D&A Markakis Pty Ltd

Friday 14th August 2020

Re: Continued objection in relation to Application SSD 9194 at 13-23 Gibbons Street (SP 60485) proposing the construction of an 18 storey student accommodation development comprising of 419 rooms

2 Section N-S

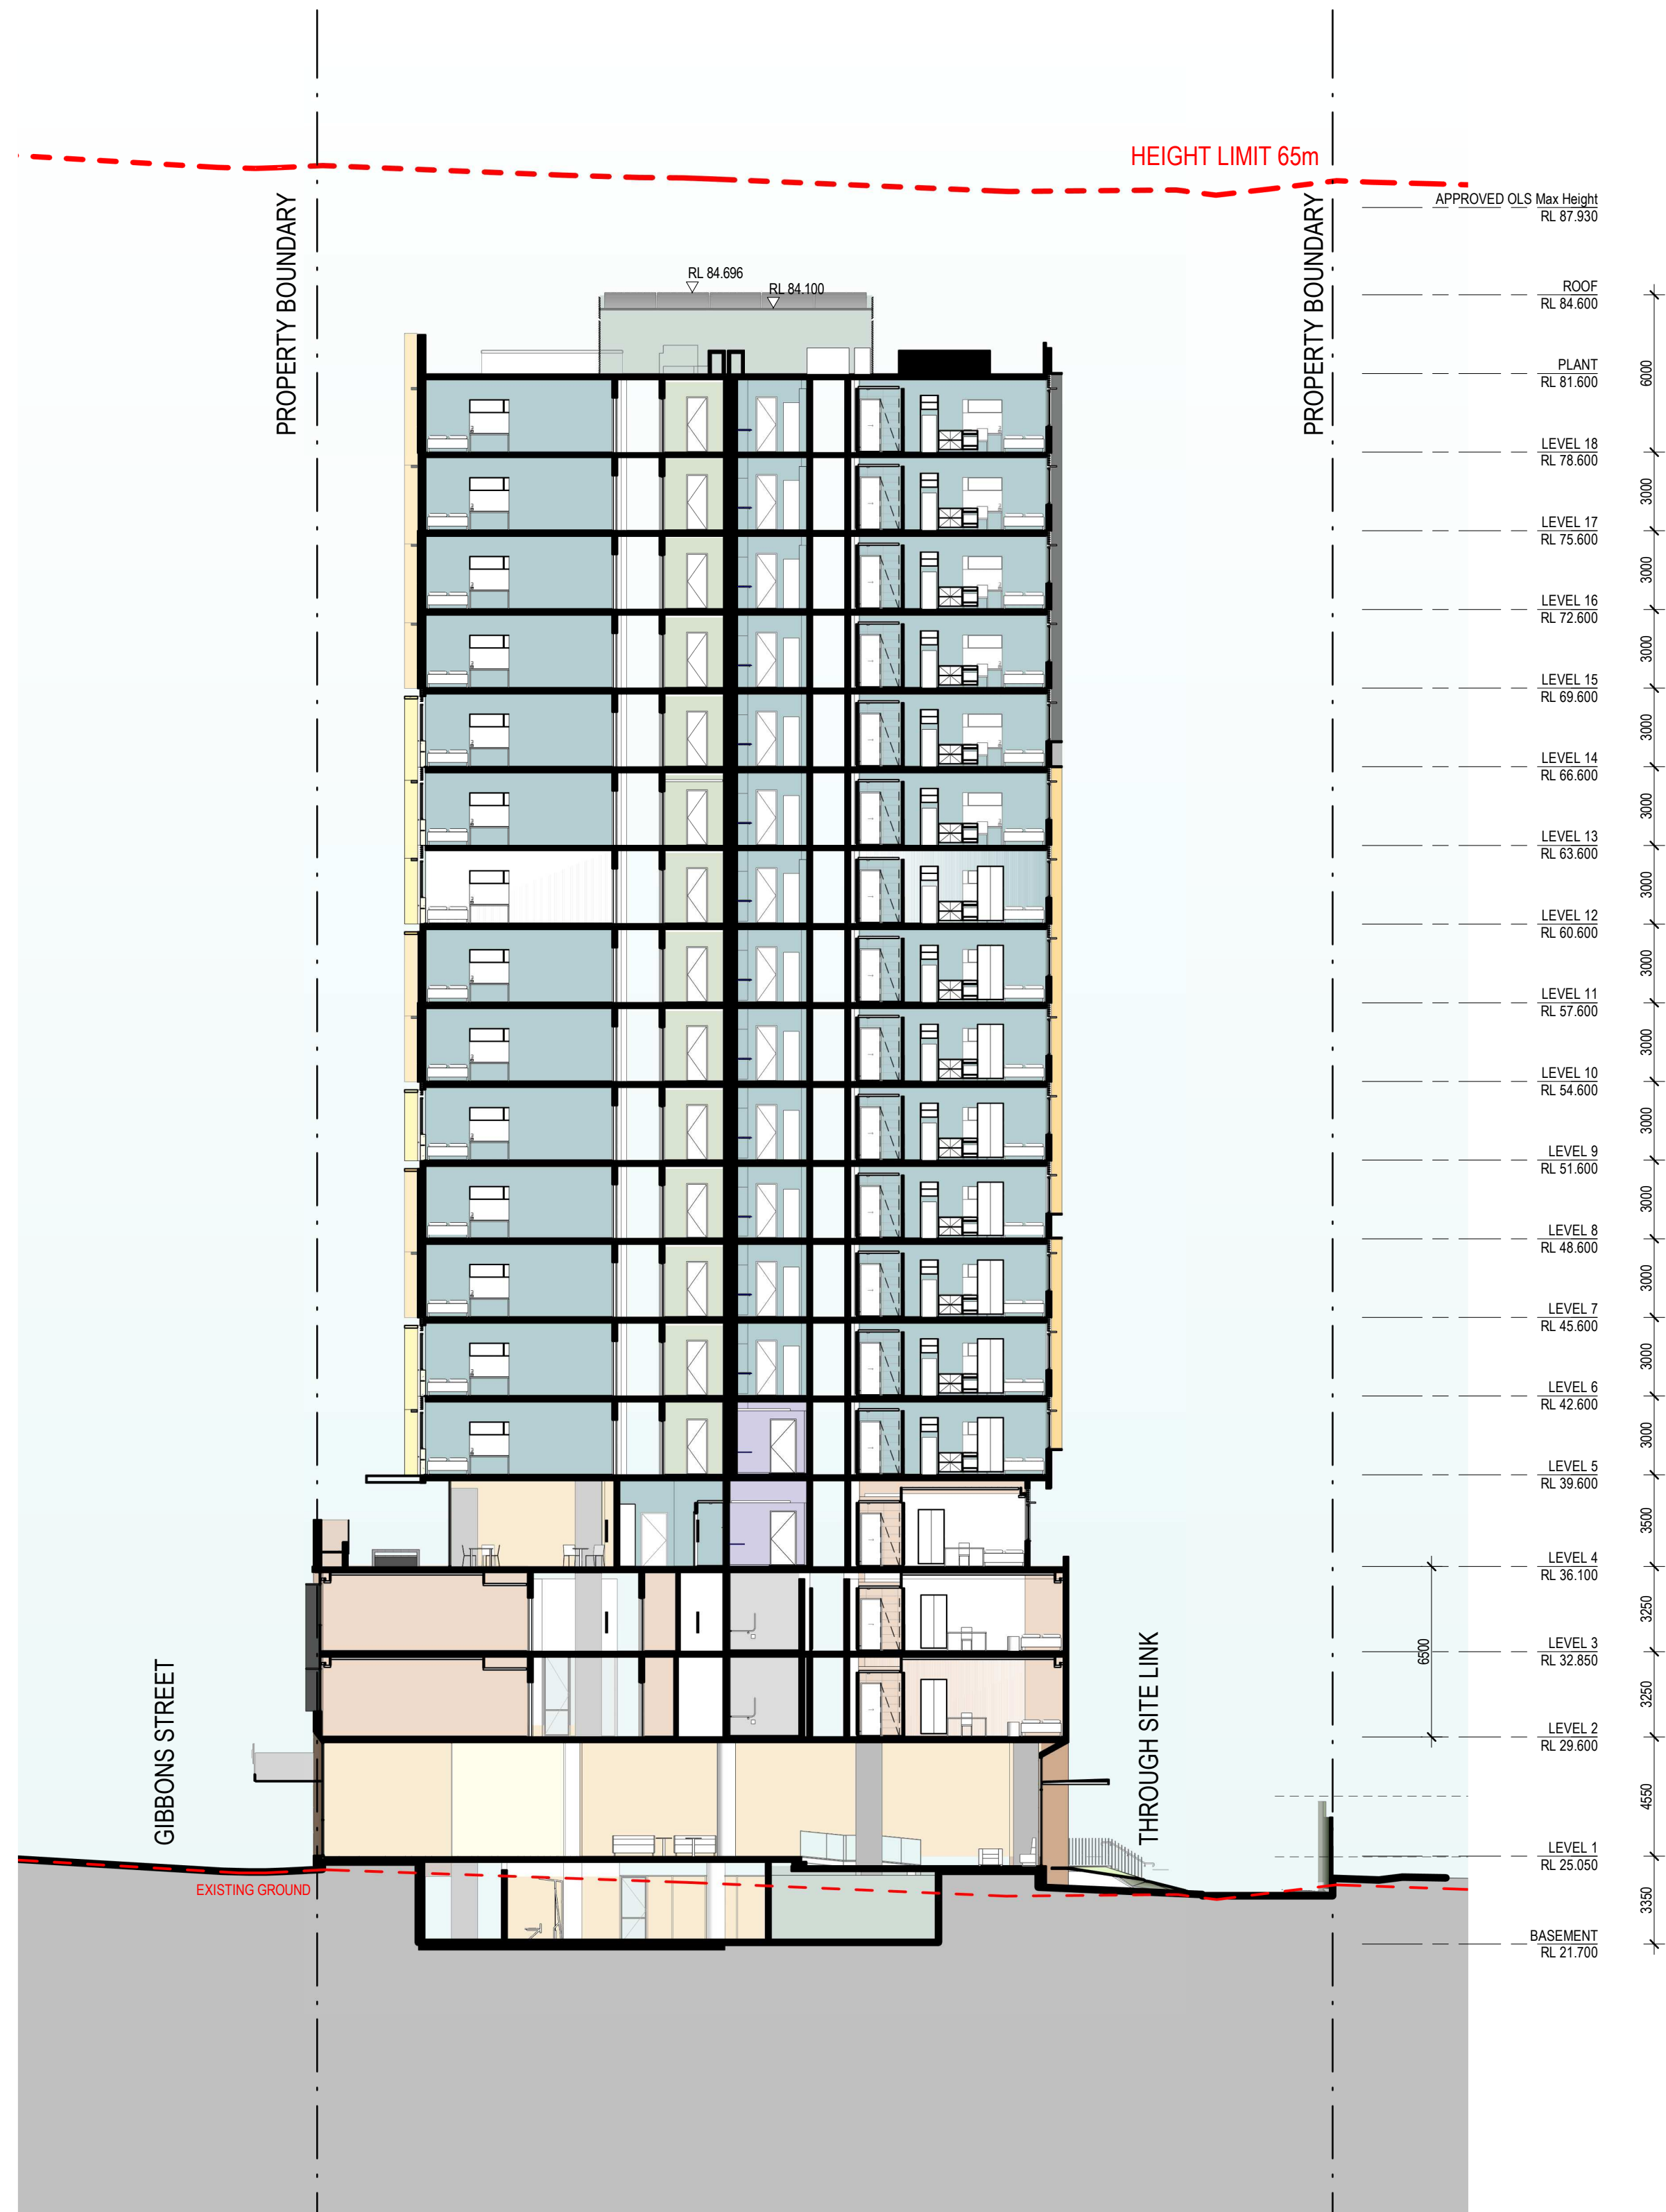
- **Inadequate setbacks to southern low scale development including the heritage church** - The revised SRTS scheme has revised the podium design so that the tower is setback further from the podium edge, however comparing Section N-S of the Architectural Drawings to its

previous iteration, the setback of the tower does not represent any material change and the building's podium appears to encroach further towards the heritage church building.
